From: Carl Pringle [REDACTED]
Sent: 20 February 2019 09:55
To: Charlotte Easton
Subject: Re: 9 Burley Road, Felpham FP/7/19/CLP

I write to your regarding a Certificate of Lawfulness for a detached garage at 9 Burley Road, Felpham.

PROPOSED TYPICAL SIDE ELEVATION
@1:50

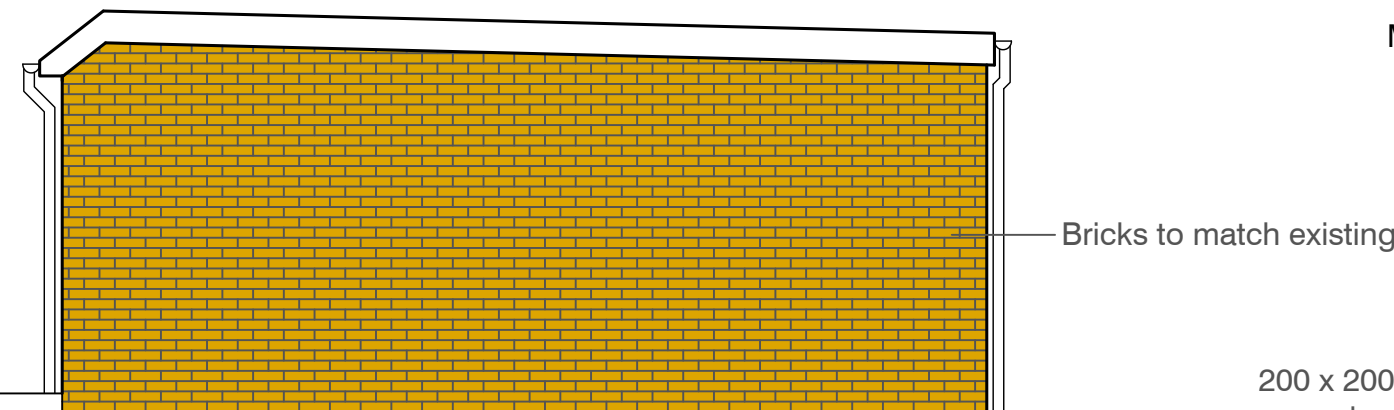
I am just in the process of writing the report for your application, however, as I was checking the plans noticed that on the Proposed Typical side elevation the appears to be a discrepancy with regard to the height. The Garage

appears to shown at a height of approximately 2.7m – could you confirm that the garage would be no higher than 2.5m please.

Yes 2.5m... 5m was a typo.

I did not appear to have that email. I can confirm the garage will not be any higher than 5m in height, the annotation must be a mistake.
